**From:** Daniel Sellar [REDACTED]  
**Sent:** 17 November 2014 13:02  
**To:** Anita Gardner  
**Subject:** R/243/14/PL - Proposed Development at 69 Broadmark Lane, Rustington

I am writing to you with regard to the above planning application. We have been in dialogue with the developer, Mr Peter Leech for a number of weeks. Below is a record of those emails. As a result of this dialogue he has agreed to undertake a number of revisions to his scheme. In terms of planning matters, the main concerns to us are the following:

Drawing 6
Proposed Location &
Block Plan

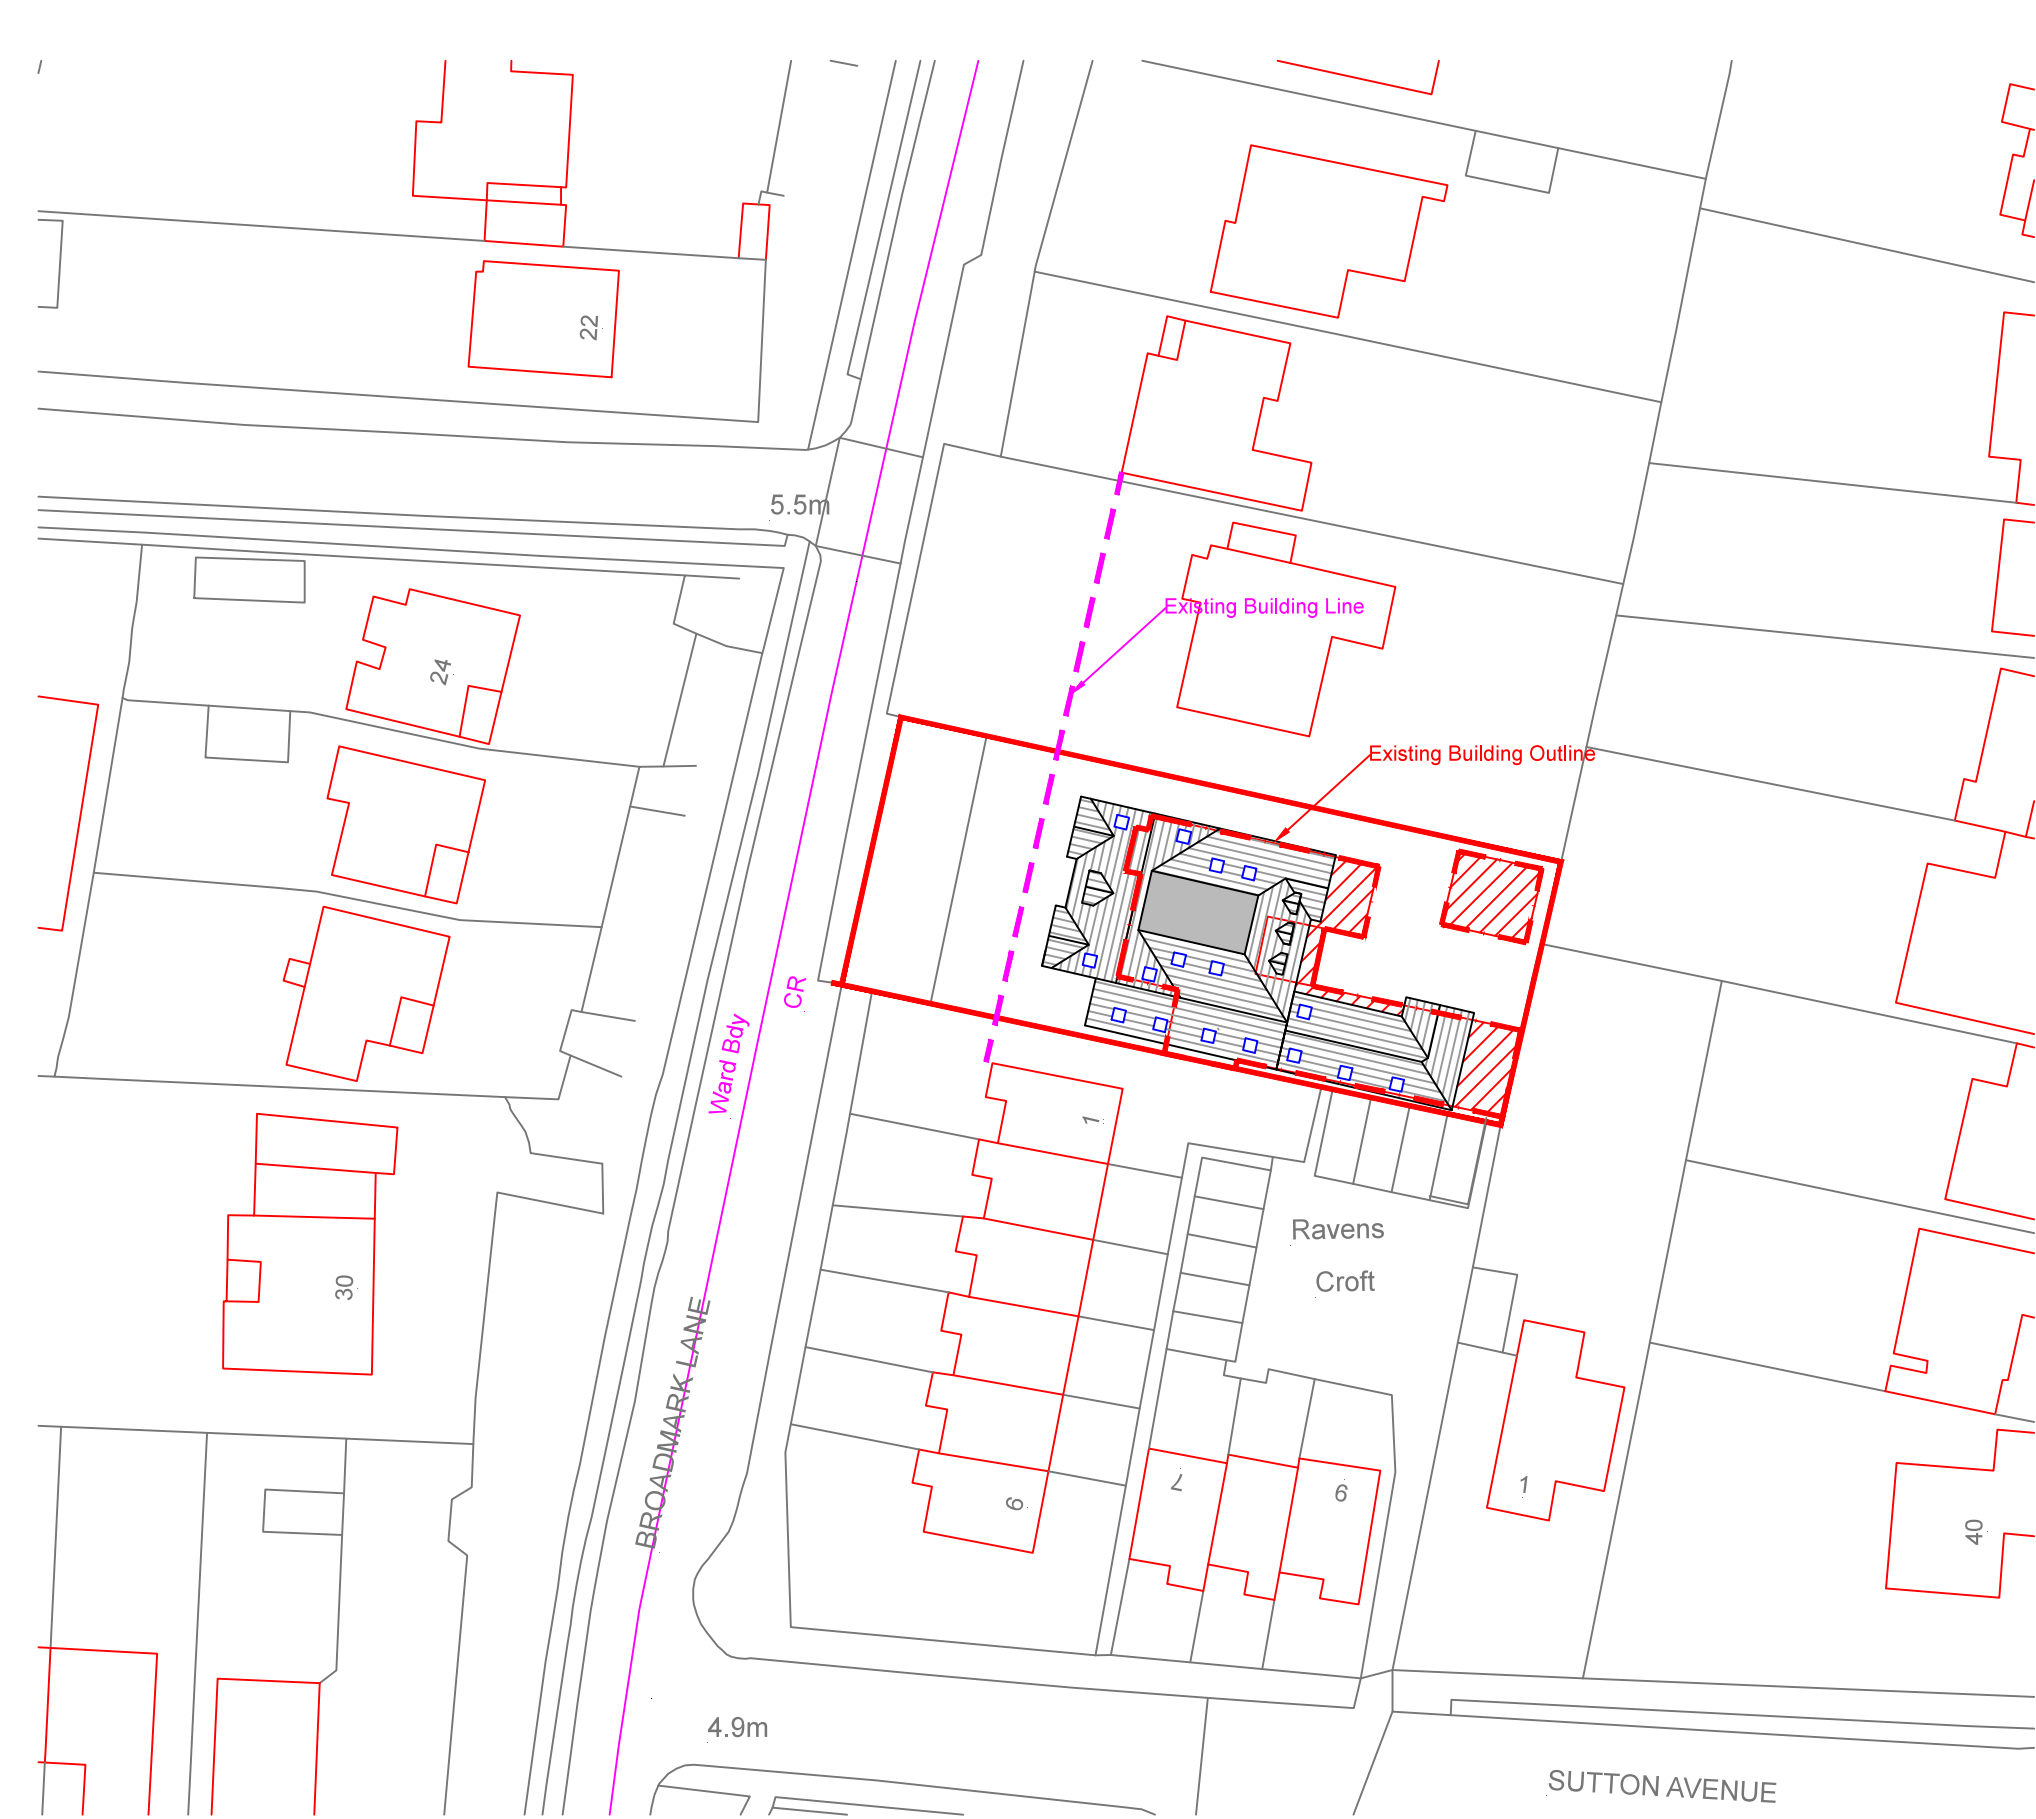
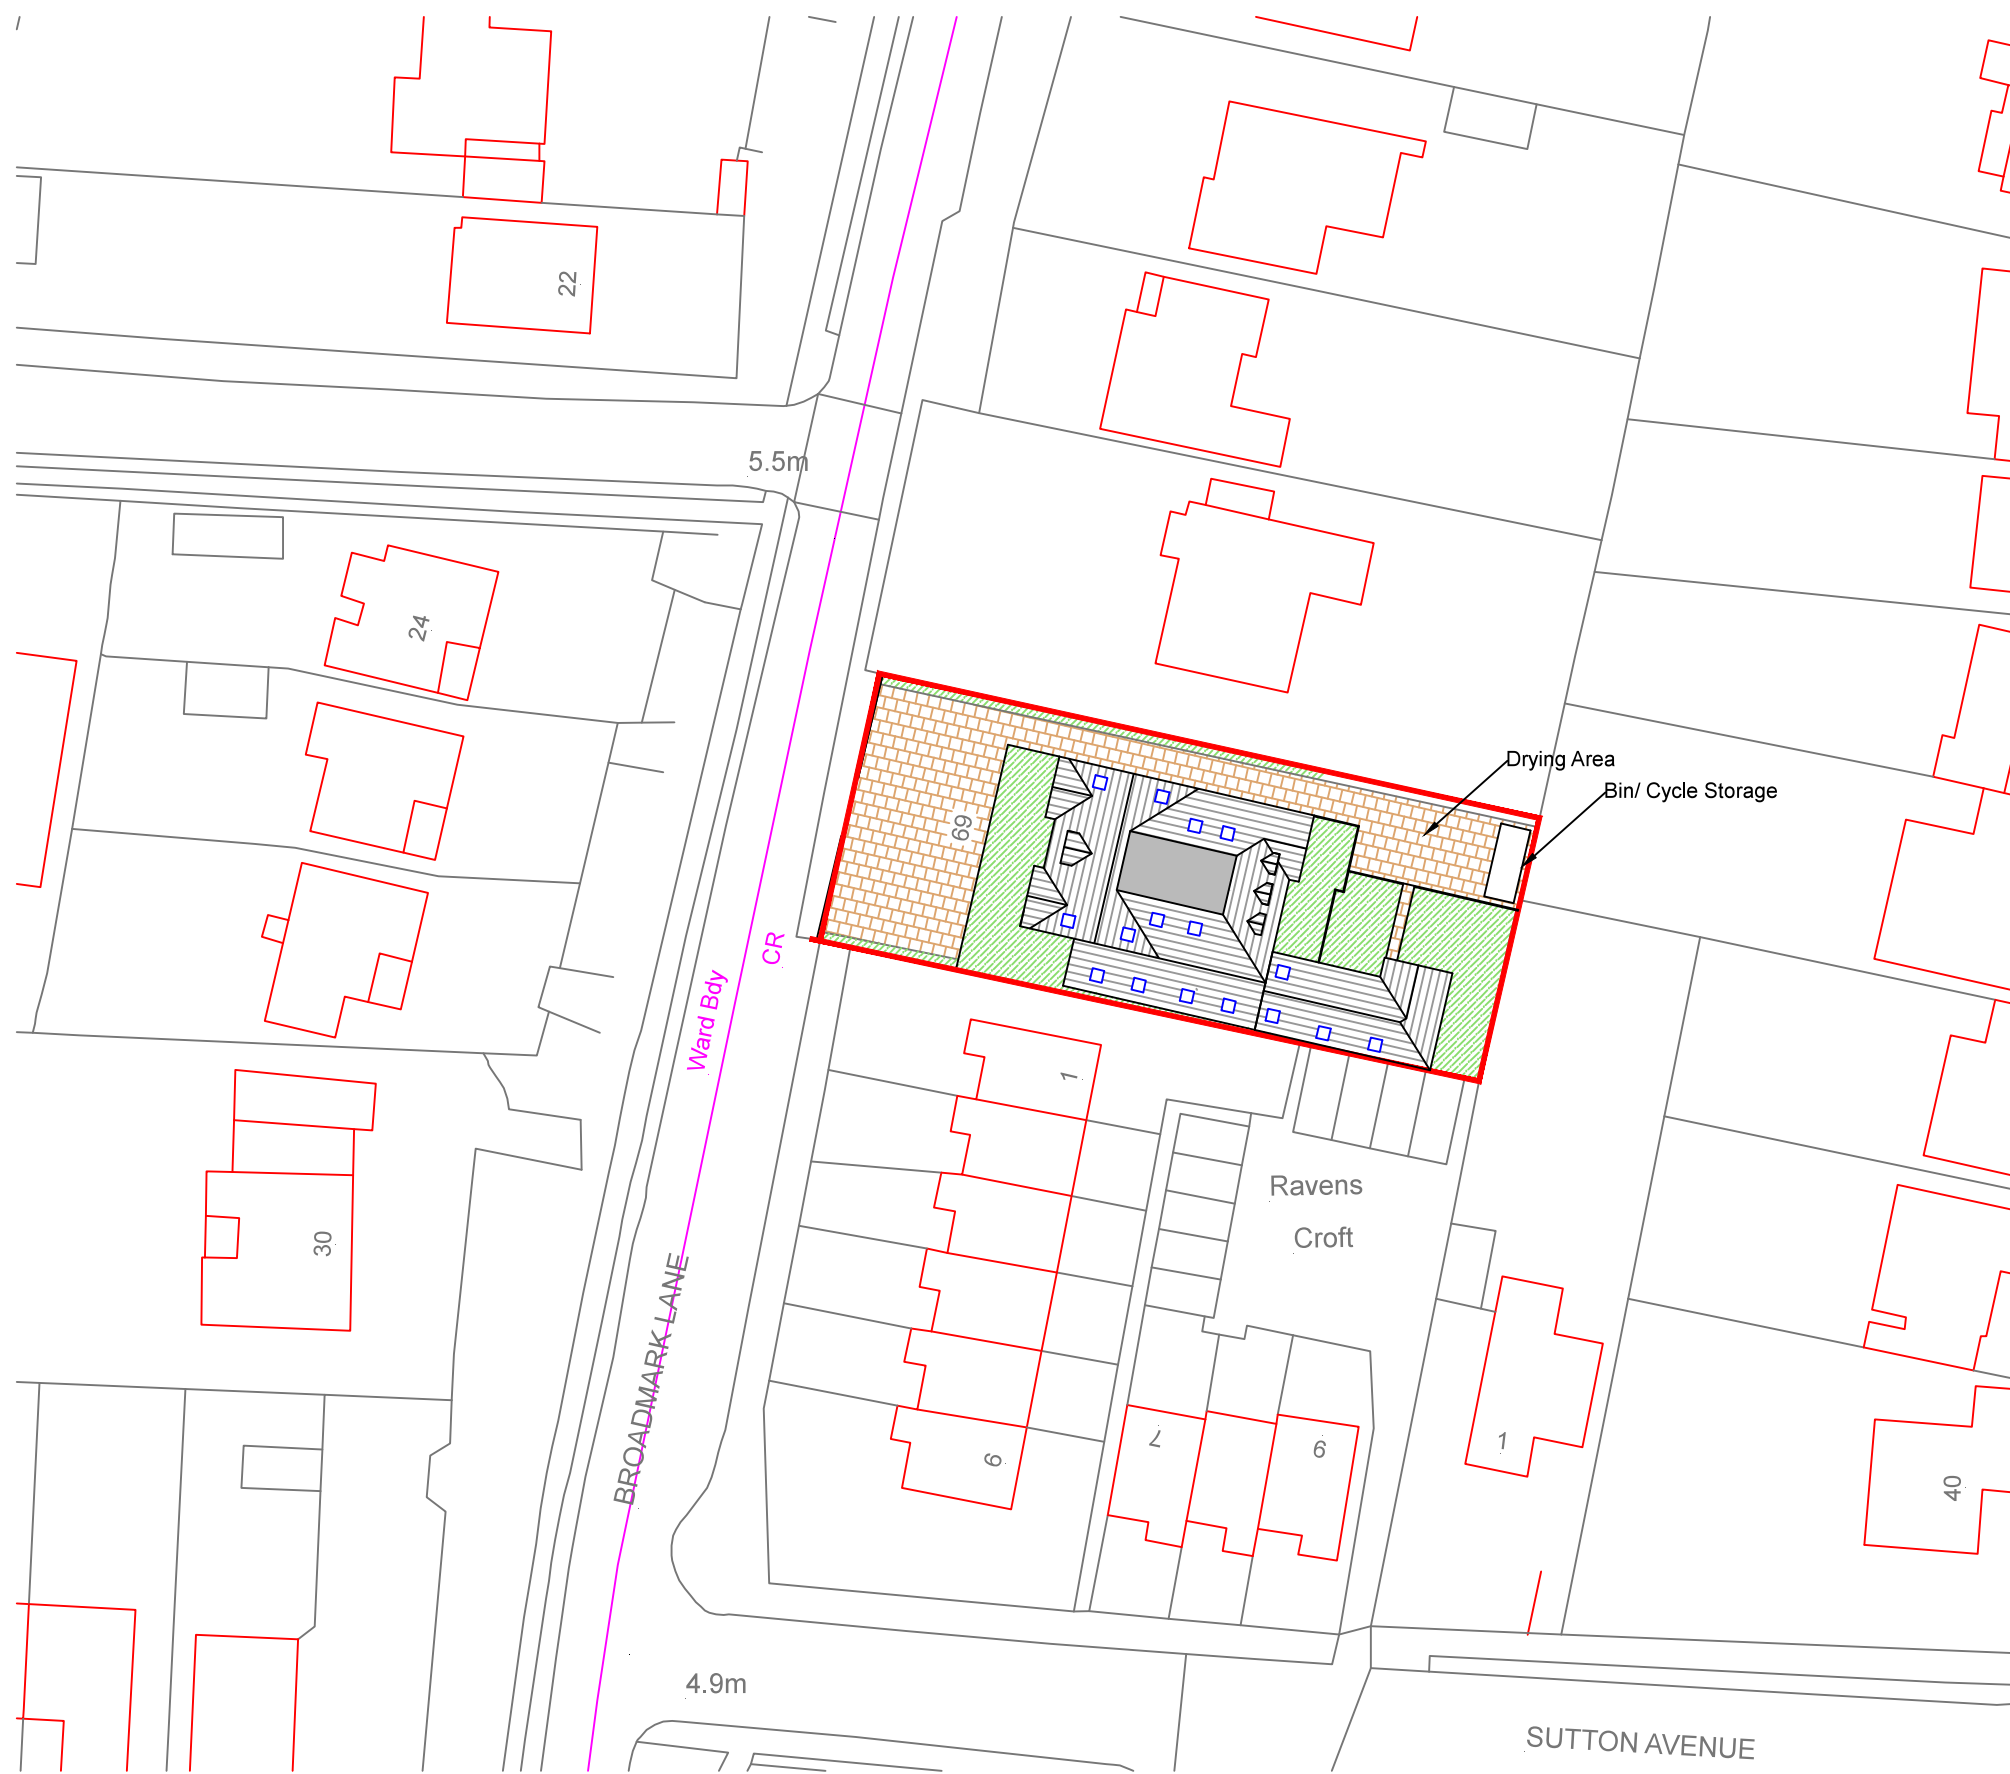
4. **Plan inaccuracies** – A number of your plans appear to be incorrect. I attach my mother's mark up from the design and access statement you left with her to review. Some plans appear to show my mother's ground floor bedroom further away from the boundary than is actually the case, and in some instances it's missed off entirely, giving the impression that your development is further away from our property than is actually the case – I would expect you to resubmit those plans as an addendum to the Council to enable to make a fair assessment of impact. Please also send me a copy of these revised plans so I may review them with her. The plan inaccuracies are a genuine mistake and we have drawn the diagrams from the previously submitted documents to the council and the ordinance survey data we acquired. We can correct these and re-submit them to the council.

Additionally he has agreed to resubmit the inaccurate plans to correctly show our southern extension, which runs up tight to our southern boundary wall. He has also agreed to a full photographic condition survey of our property.
